Re: Peer Review of Revised Heritage Impact Statement
Griffith House as part The St George Hospital Masterplan
Authored by Urbis and dated October 2012

Provide a peer review of the revised Heritage Impact Statement noted above.

Sheet/ Zone	Drawn	Checked	Date	Scale/s
	SH		14.10.11	1:500
Drawing Title				
SITE PLAN

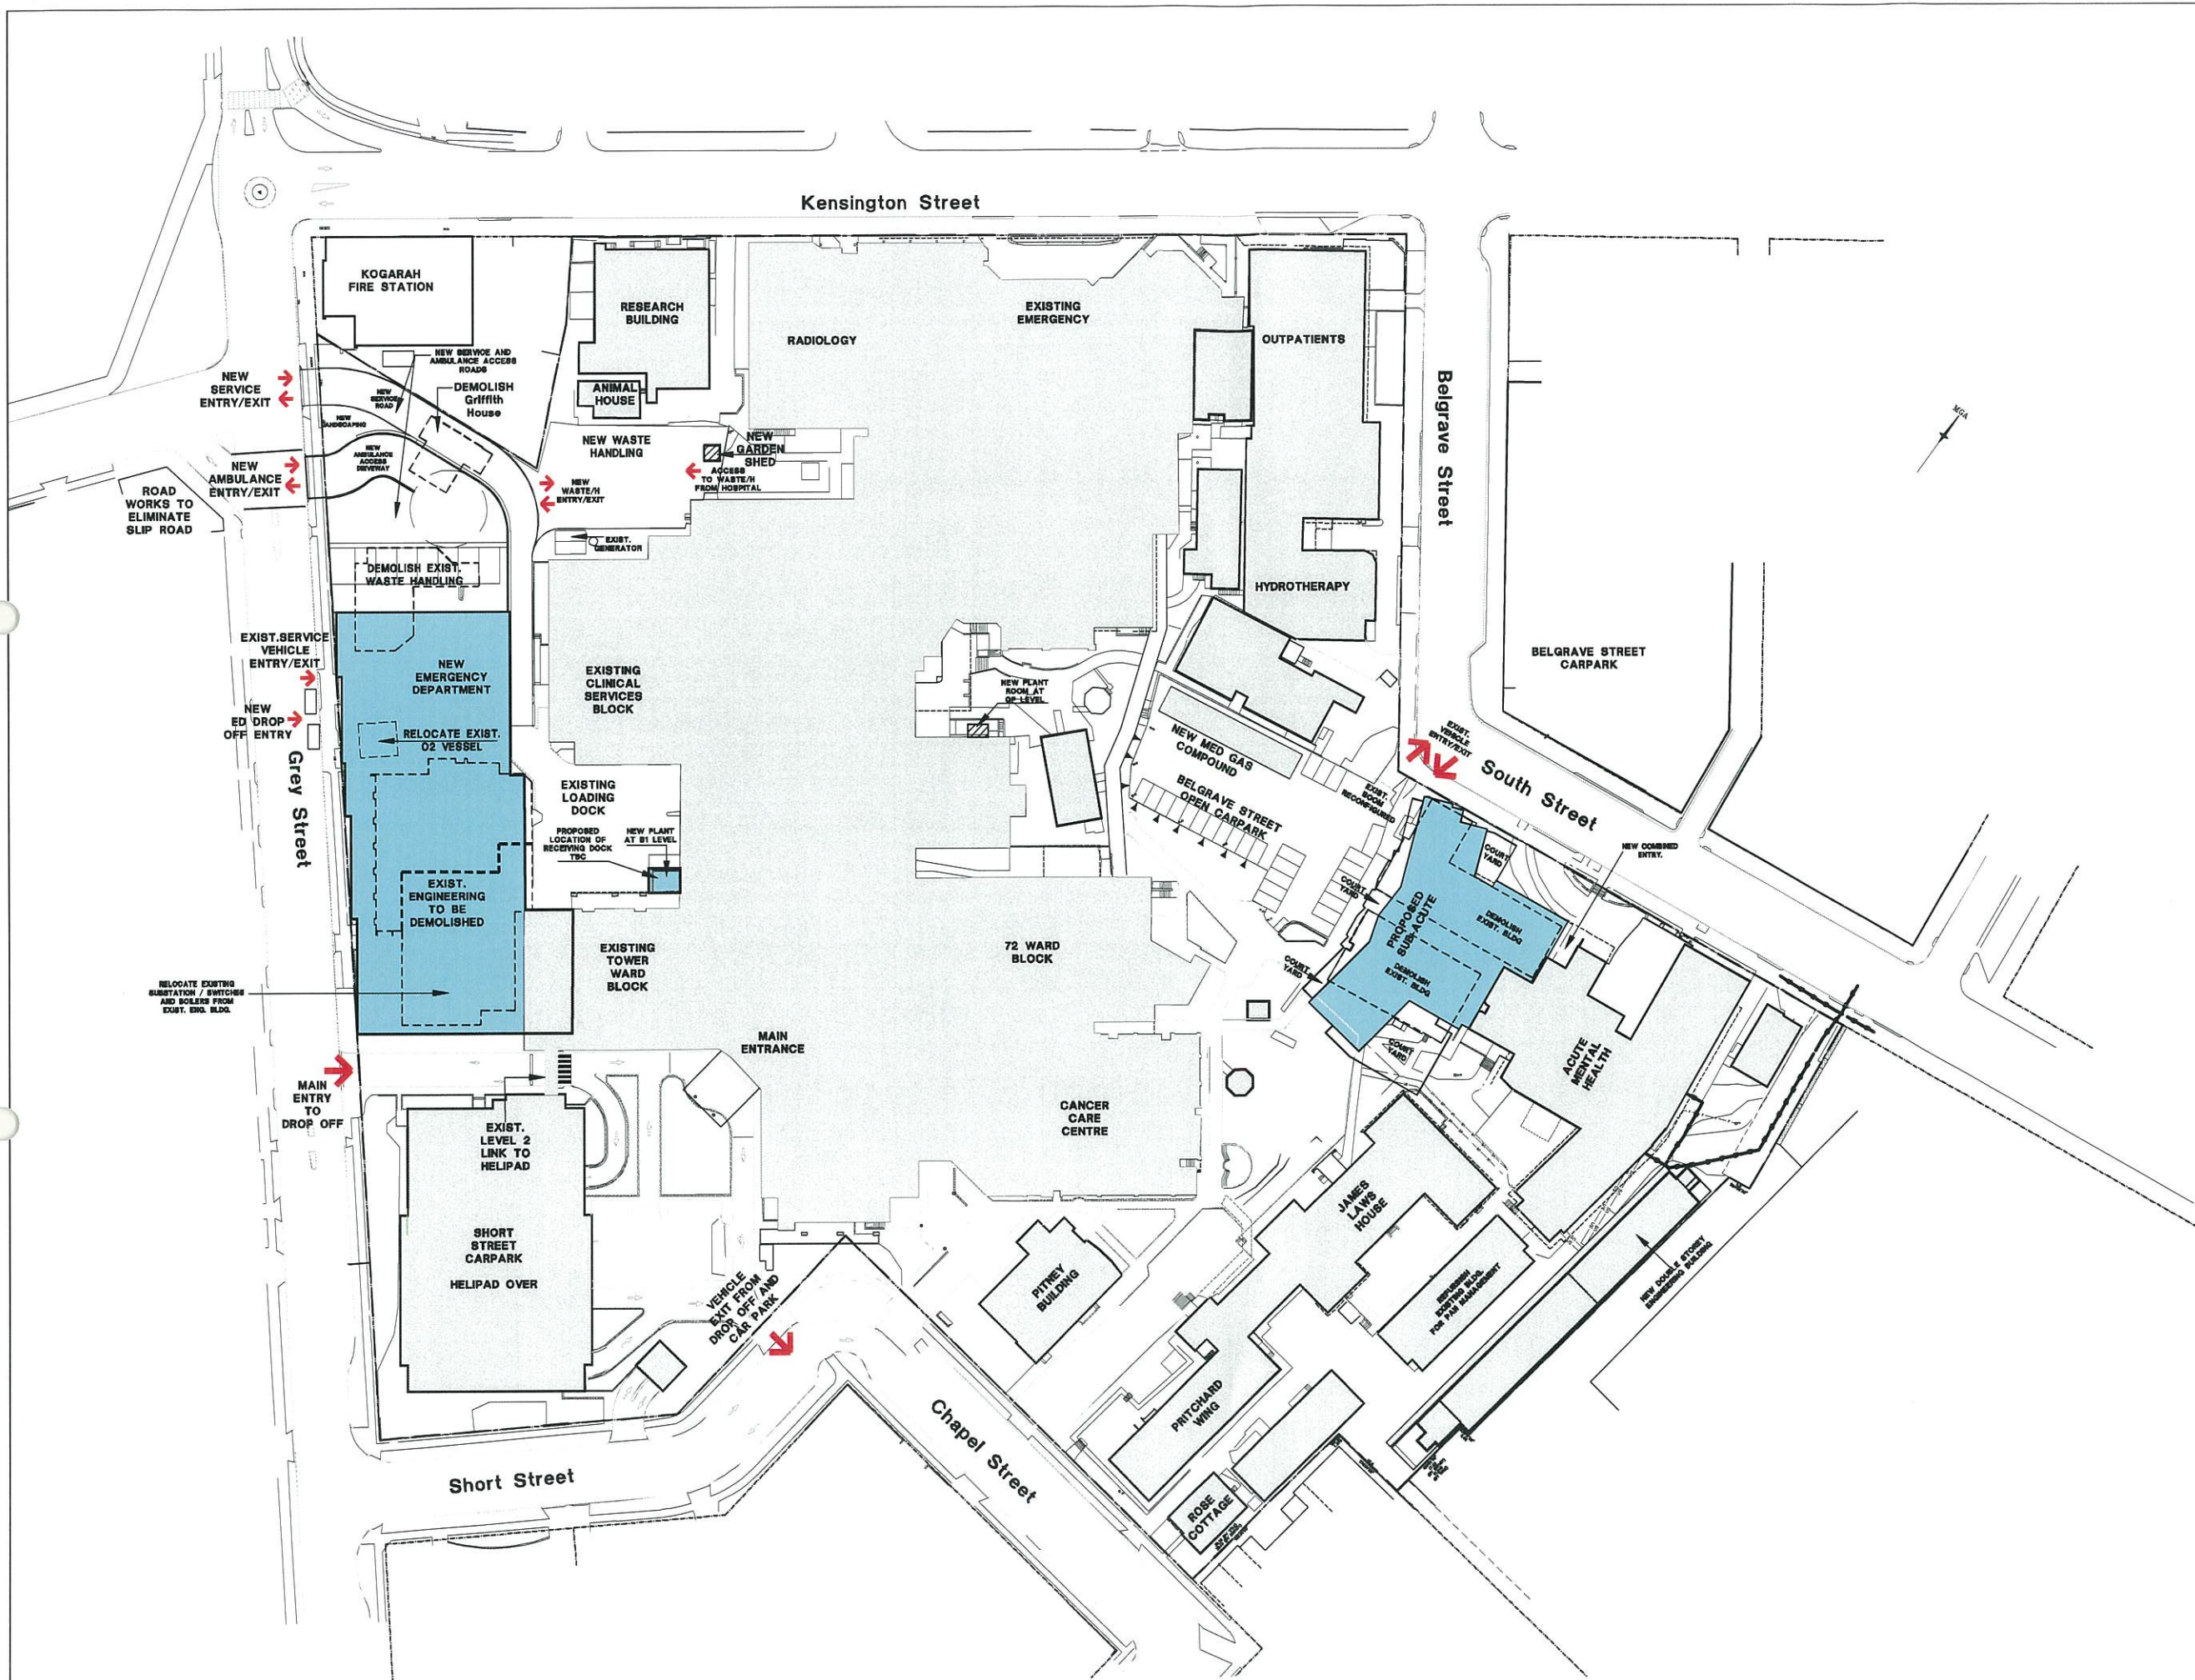
Overall, the Report is adequate for its intended purpose. However the Report and the drawing supplied, (SGHED-A-P-SS-1), do not address a major risk to the carriage of the project with regard to the consent authority.

3. More graphic emphasis should be given to the encroachment of the Emergency Department onto the outline of Griffith House and a specific, compelling use, be given to the car parking on the Griffith House site. (i.e, the car spaces have some specific allocation)

FIGURE 1 – AERIAL OF SITE

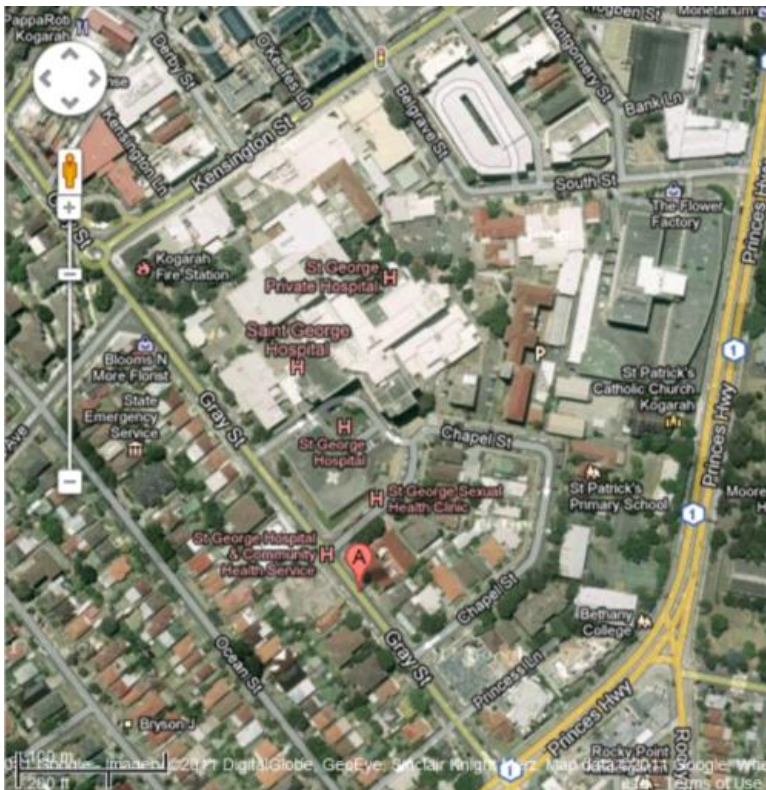
The site description is adequate. It would be assisted if the photos were of larger format and there was a more comprehensive photographic coverage of the relationship of Griffith House to the streetscape and to the existing hospital.
